**COMMENTS ON APPLICANT'S RESPONSES TO THE EXAMINING AUTHORITY'S
SECOND WRITTEN QUESTIONS REGARDING THE APPLICATION BY SUFFOLK
COUNTY COUNCIL FOR AN ORDER GRANTING DEVELOPMENT CONSENT FOR THE
LAKE LOTHING THIRD CROSSING**

PLANNING INSPECTORATE REFERENCE NUMBER TR010023

**20013284 - OVERSEAS INTERESTS INC
20013285 - WAVENEY FORK TRUCKS LIMITED
20013286 - LIFT TRUCK RENTALS LIMITED,
20013287 - NEXEN LIFT TRUCKS LIMITED,
20013288 - OAKES RECRUITMENT LIMITED,
20013289 - TEAM OAKES LIMITED
20013290 - HITECH GRAND PRIX LIMITED**

DATED: 26 APRIL 2019

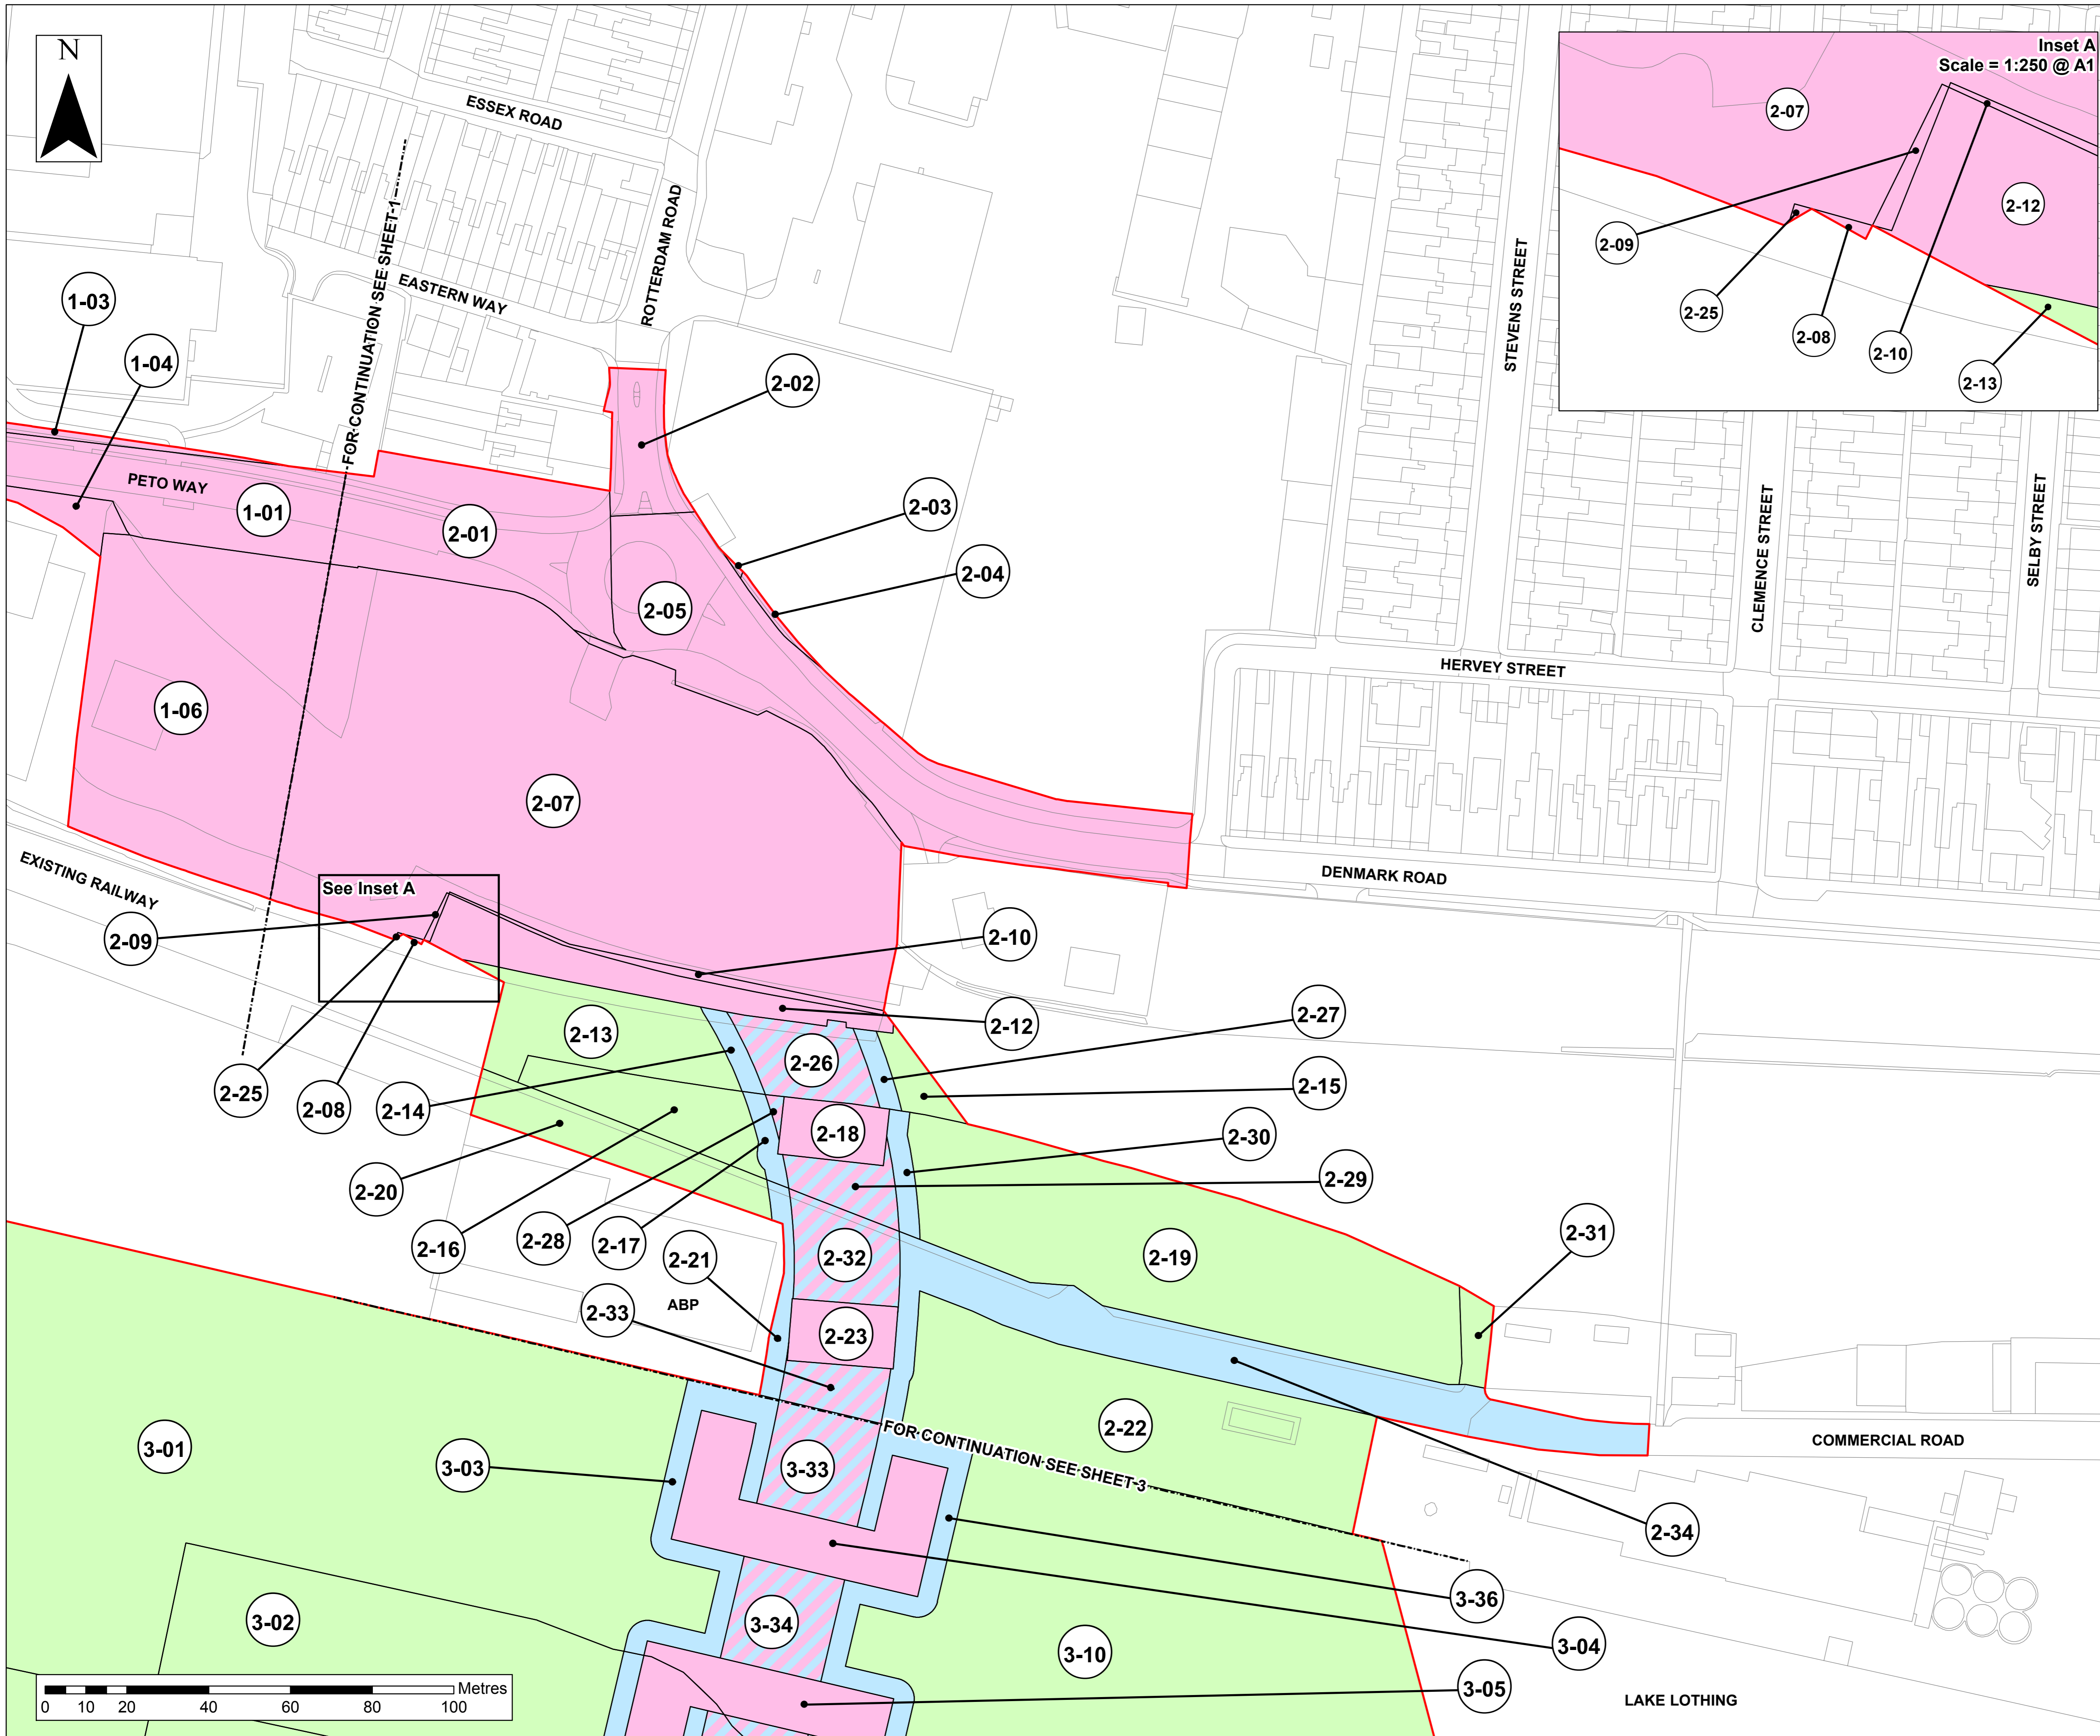
- 5 The Applicant's response to Question 1.17 provides absolutely no guarantees as to the state that Plot 3-57 is to be returned.
- 6 Indeed, the response appears to avoid the fact that Plot 3-57 is in the landownership of PFK Ling Limited and none of the Nexen Group's views on the state that Plot 3-57 should be left in would be taken into account under Article 32 as currently drafted.

- 7 The reality is that the provisions of Article 32 do nothing to preserve the functionality of services and drainage in Plot 3-57 and the Nexen Group (or the local planning authority) would have no action against the Applicant, save for in a claim for compensation.

- 8 Even if we assume that the Applicant was to ensure that any servicing to the Land currently within Plot 3-57 would remain in place and be functional following the Applicant's temporary possession of this Plot, the Applicant's response also does not take into account the fact that it is entirely possible that it may temporarily possess Plots 3-56 and 3-57 at different times or its period of temporary possession of one of these plots may exceed the other.

- 9 If Plot 3-57 was temporarily possessed for a longer period of time than the Development Land this would mean that the lack of any guarantee as to the functionality of any services and drainage would continue to impact on the development of the Development Land even when that site was returned to the Nexen Group.

Under article 32 of the DCO, any land that is occupied by the Applicant pursuant to the temporary possession powers granted by that article (of which plot 3-57 is an example) must be restored by the Applicant to the 'reasonable satisfaction' of the landowner. Whilst the Applicant does not intend to affect the functionality of services and drainage within that plot during the construction of the Scheme; such functionality would be able to be restored pursuant to that DCO provision (contained in paragraph (4) of that article).

Project	Originator	Volume
1069948-WSP-HAC-LL-DR-CH-0002		
Location	Type	Role

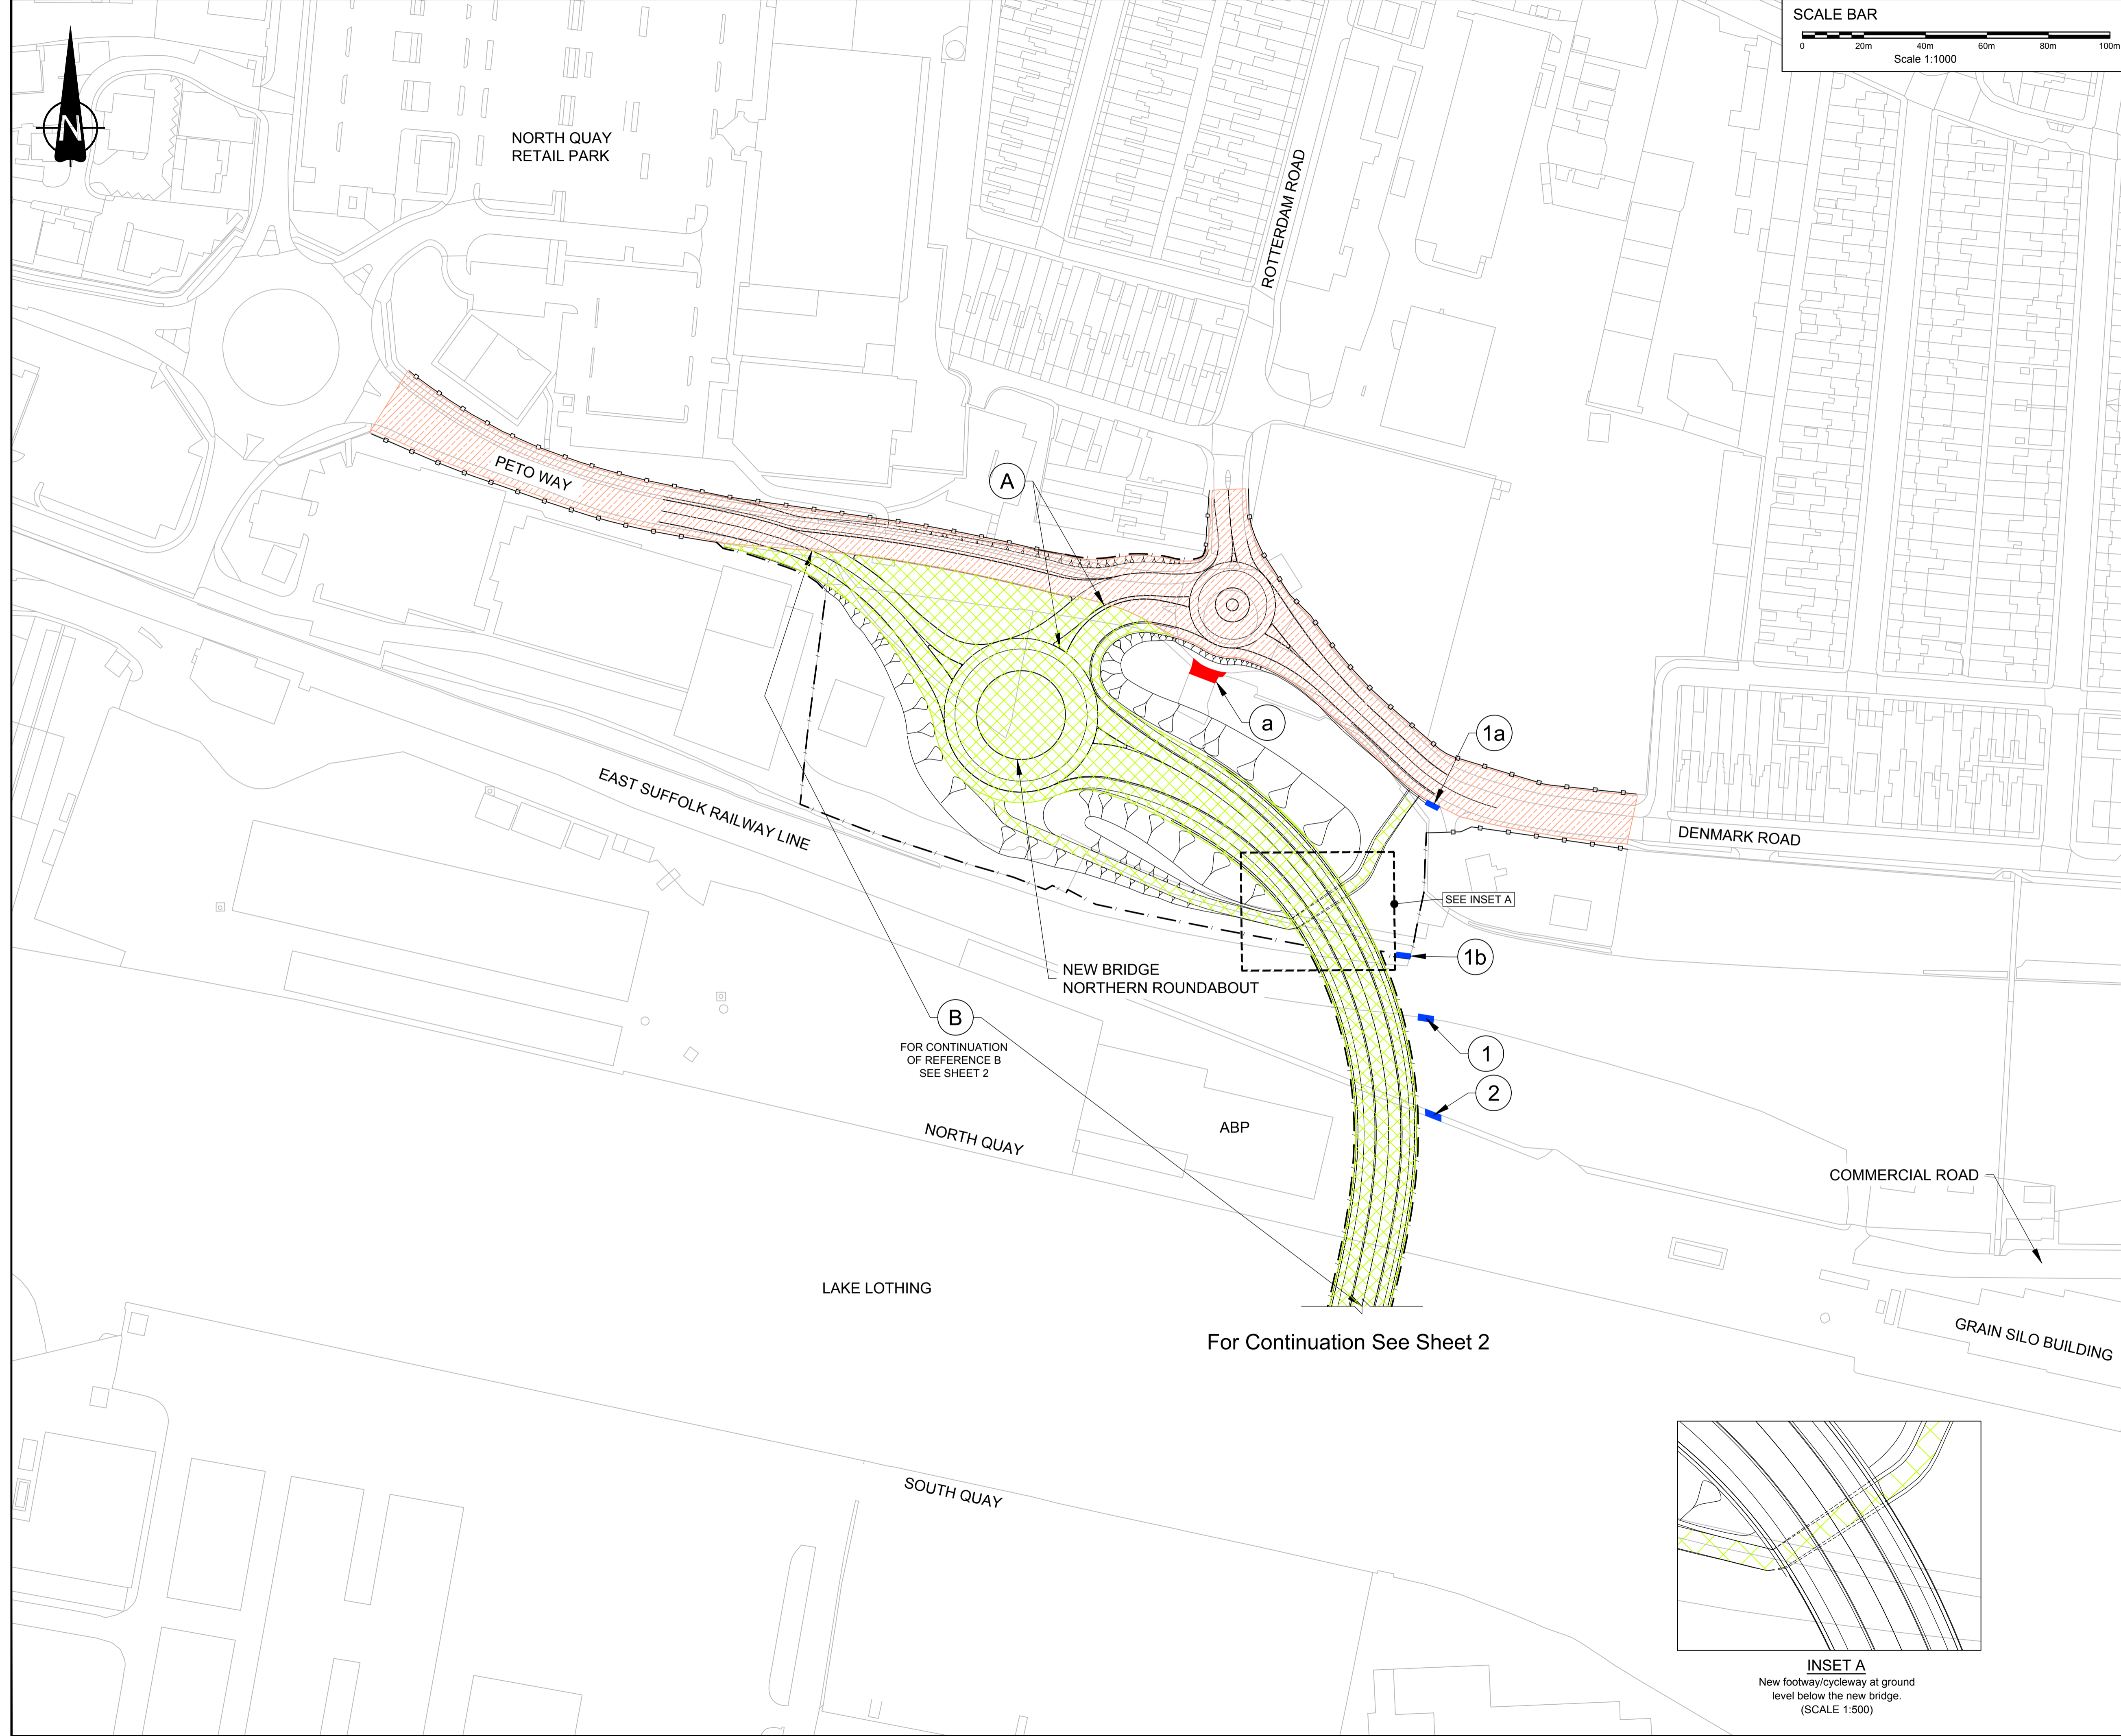
- 21 The ExA should be aware that the current form of the draft DCO (see Article 10 and Schedule 4 Part 3) and the (as submitted) Rights of Way & Access Plan (1069948-WSP-HAC-LL-RD-CH-0003) do not require the provision of a replacement vehicular (or temporary) access to the Land before the private means of access is stopped up. This is at odds with the Applicant's response to this Question 1.18 and the Nexen Group urge the Applicant to update Schedule 4 of the draft DCO to require the provision of a replacement, separate, vehicular access (with services and utilities being available of sufficient capacity therein) to the Development Land before the

current private means of access is stopped up. As we have stated at length previously, it is the Nexen Group's position that the only way in which a suitable separate vehicular access to the Land may be provided without risk of interruption during the construction period or future maintenance of the Proposed Scheme is by way of an access to the eastern edge of the current Lings site.

- 22 This solution would merely require the access to the eastern edge of the Lings site, which now forms part of the Applicant's "non-material" changes to the Proposed Scheme, to be physically linked and necessary rights granted allowing access/egress to the Development Land, over the private access road to the south of the Development Land. Since the new southern access road constructed on the east of the Lings site by the Applicant is understood to extend and join with the existing private access road adjoining the south of the Development Land it makes sense for it to serve the Development Land too. Mayer Brown's proposal as set out in previous representations is a wider road (at 7.5 metres) and it is submitted that any additional cost involved in the construction of this is substantially less than the compensation liability if this is not provided. This alternative access could, of course, provide an alternative access to the Land as a whole during construction works of the bridge itself and provide a guarantee that those construction works would not interrupt continuous access/egress to the Land which we have already explained is important to the Nexen Group's business operations.
